**From:** [Jan Ashley-Fenn](mailto:Jan.Ashley-Fenn@greatercambridgeplanning.org)  
**To:** [info@acaciatreesurgery.co.uk](mailto:info@acaciatreesurgery.co.uk)  
**Subject:** RE: Application for Works to Trees in a Conservation Area - Orchard House Field Road Kingston (ref 23/1251/TTCA)  
**Date:** 25 October 2023 13:56:00

**Ref. WASHINGTON, Orchard House, Kingston CB23 2NQ**

**Planning Reference Number: 23/1251/TTCA**

**Re: T1 Willow**

Ref. WASHINGTON
Tree Location Plan

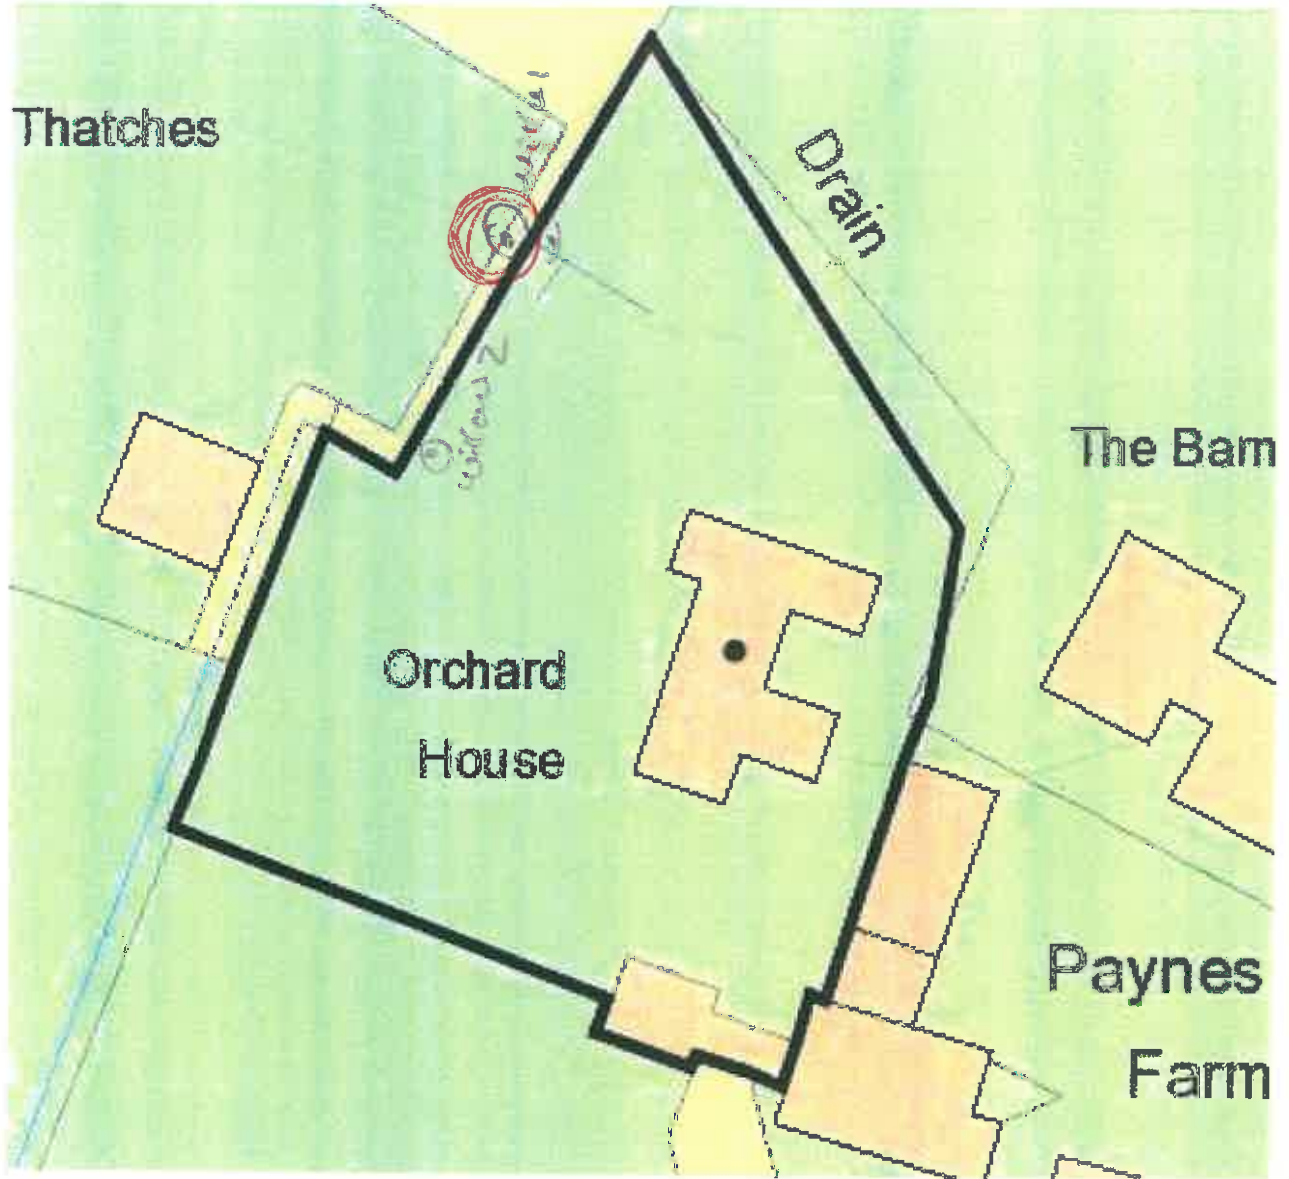
The application states that the tree requiring work is located at Orchard House, Field Road but your plan and proposal is stating that the tree stands in the neighbouring property at The Thatchers. The location address on the application always refers to where the tree trunk stands which is not always necessarily the address of the applicant. Please confirm the location address of this tree.
